DECISION DELEGATED TO HEAD OF PLANNING

Application No: H14-0821-24 **Applicant:** Neil Brown Engineering Ltd

Proposal: Erection of 11 industrial units (Use Classes E(g), B2 and B8) - Approved under H14-0221-21. Modification of Condition 2 to allow amendments to previously approved plans

Location: Land Adjacent To Neil Brown Engineering Ltd Benner Road Pinchbeck

| SCALE<br>1:100 @ A2 | DRNG No.<br>2772-A2-03a |

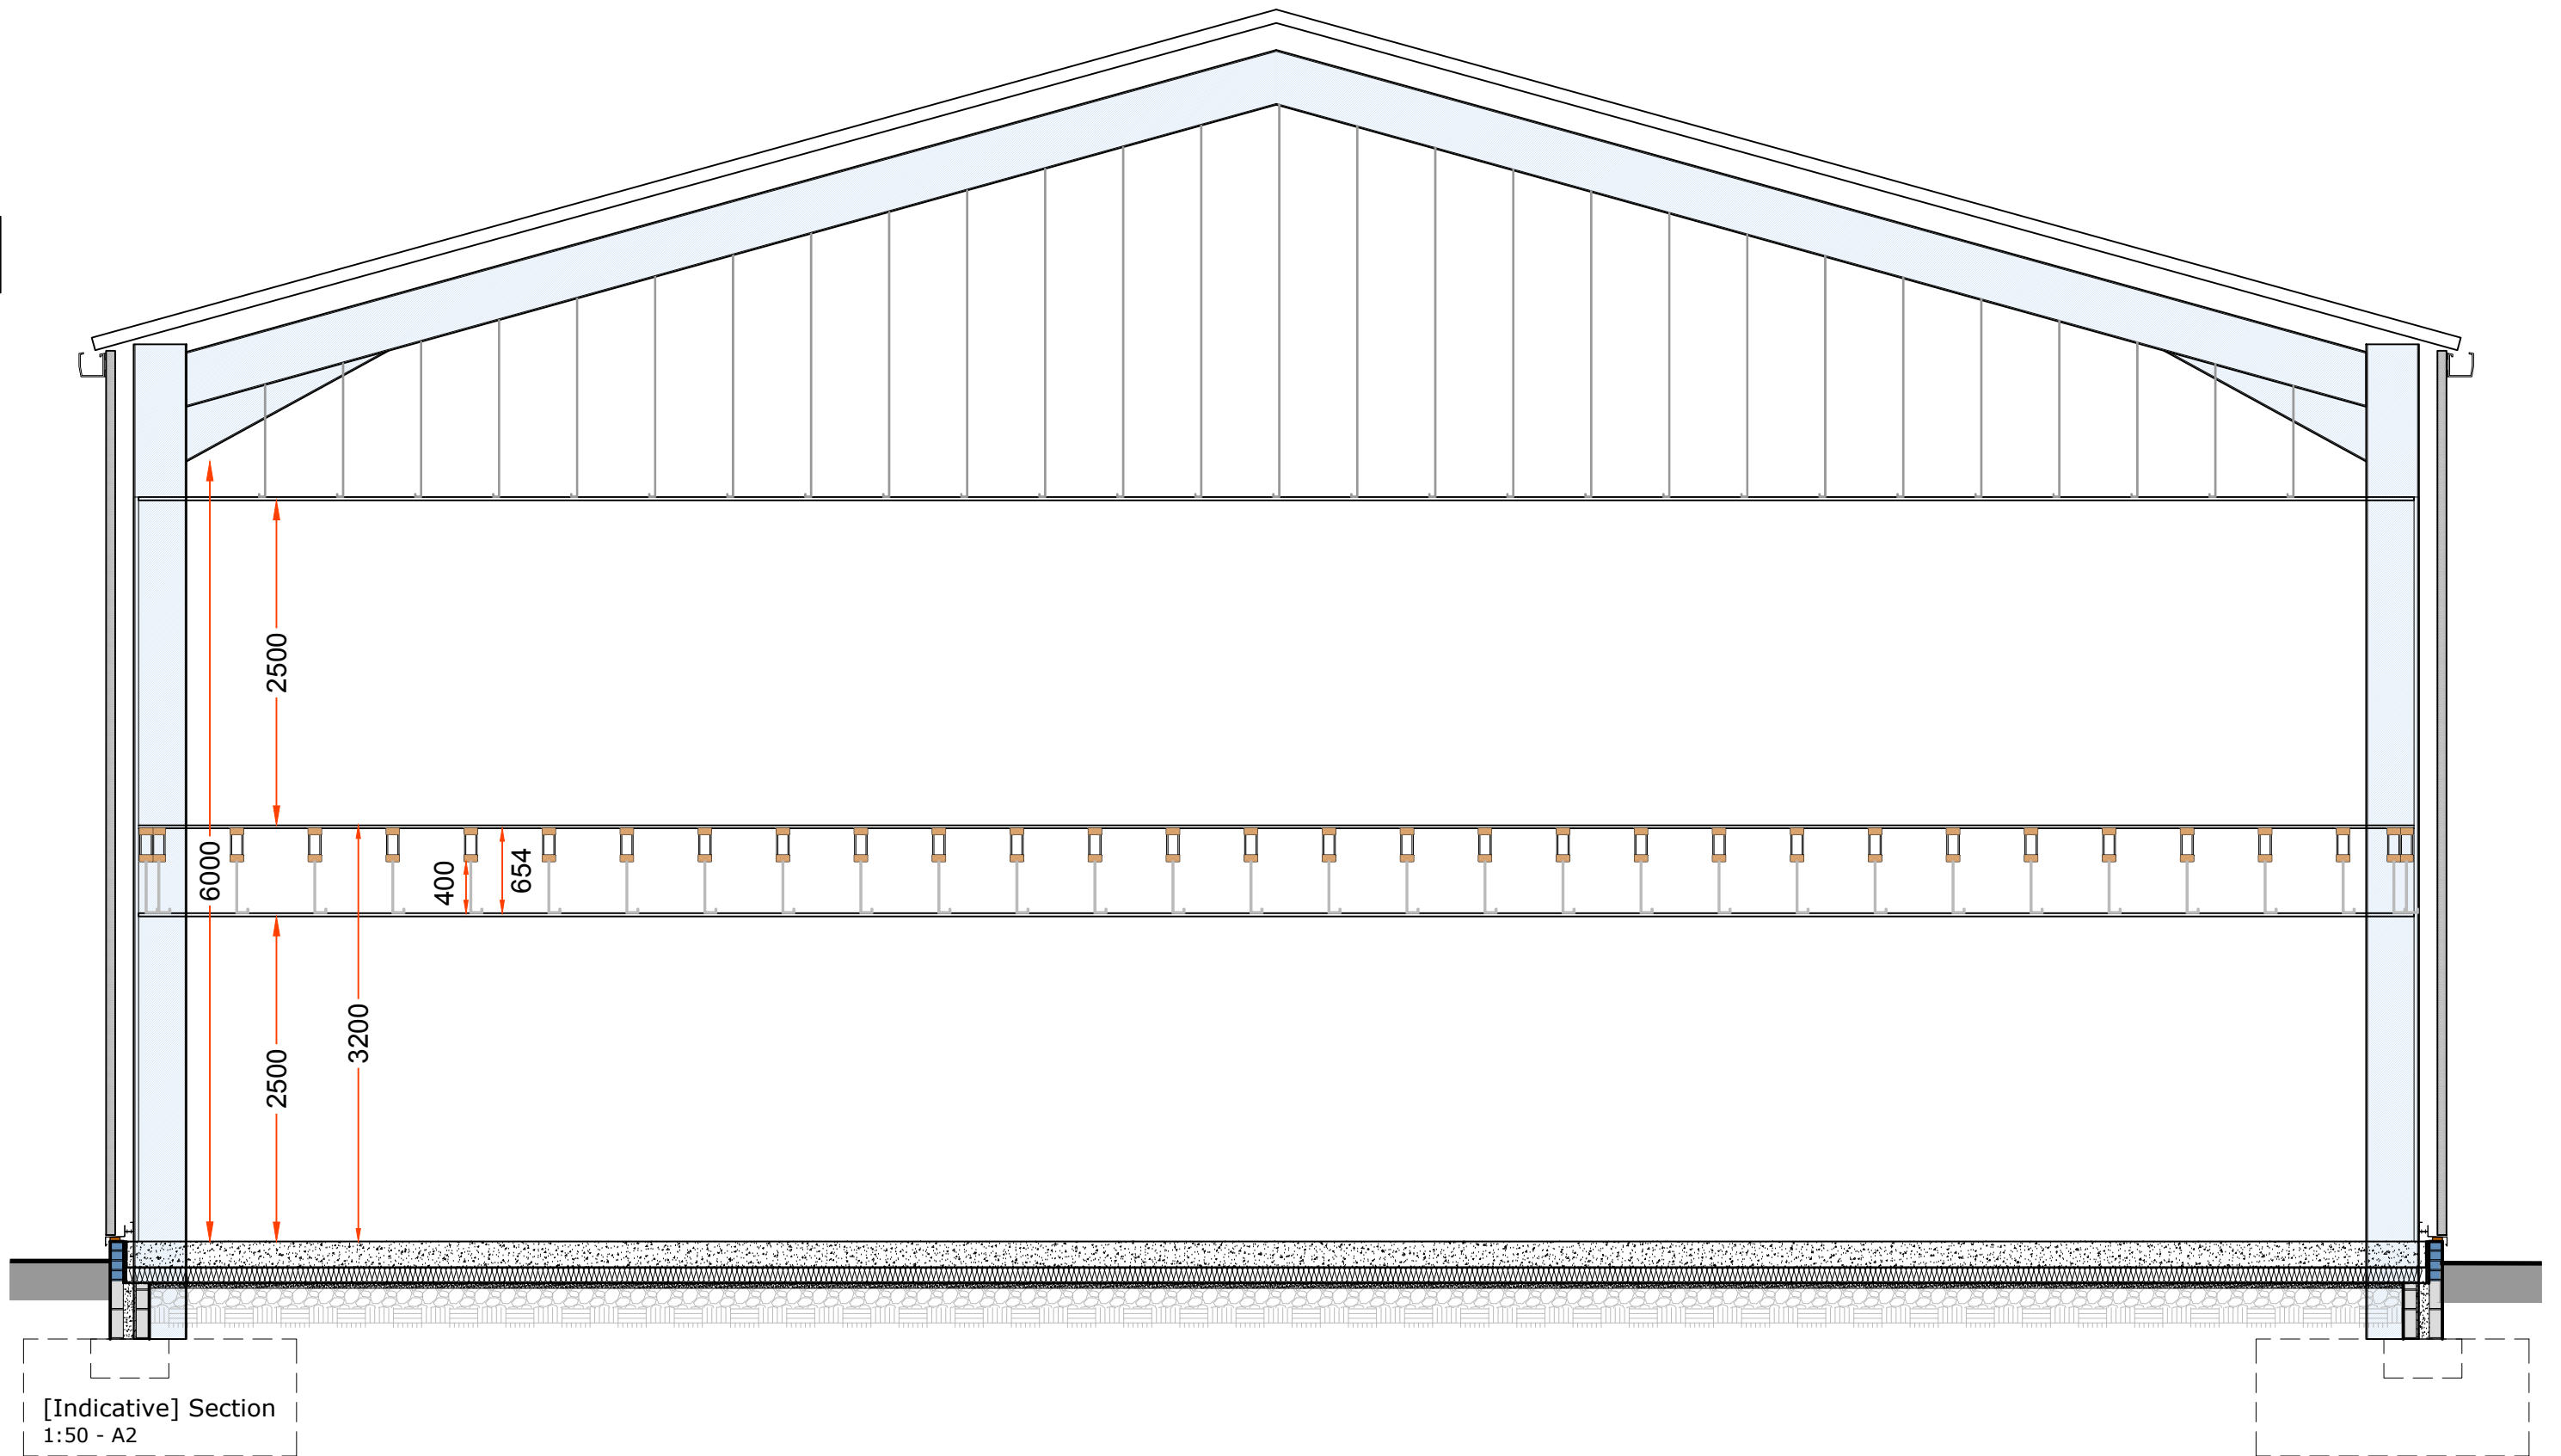
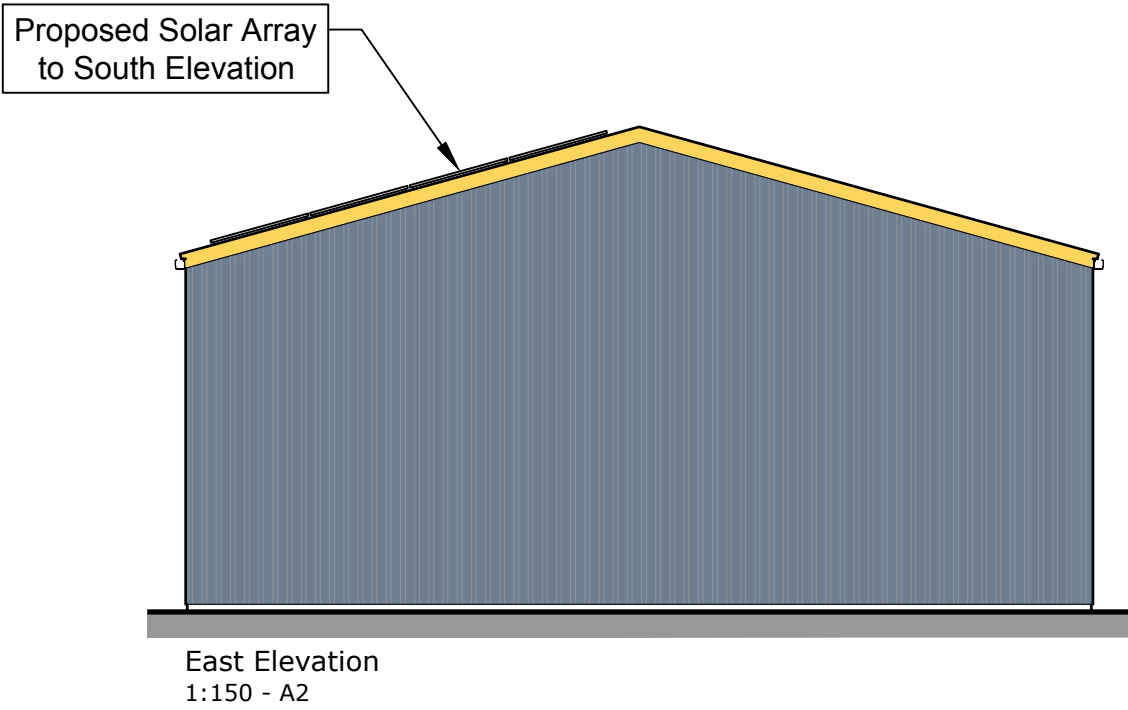
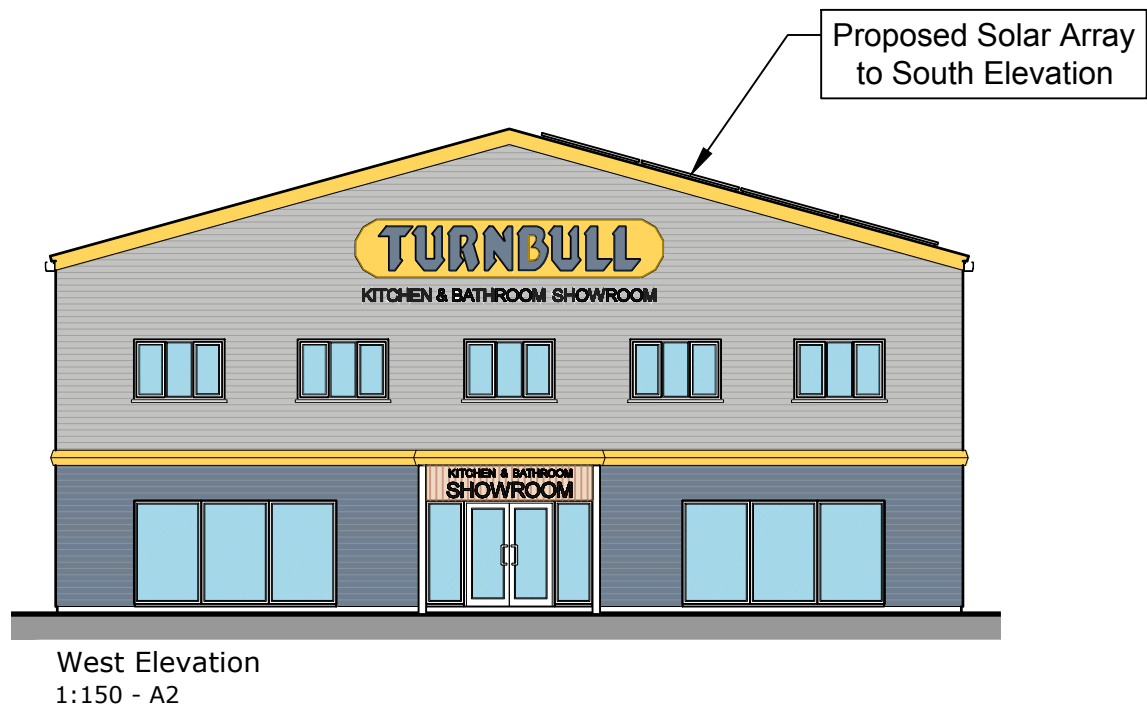
The proposed new structure is: 18 metres wide. 9.5 metres high and 65 metres long. The floor space is 1818 square metres.

The proposals include solar panels along the southern roof element of the structure and as such this is an improvement in climate change terms compared with the approved scheme.
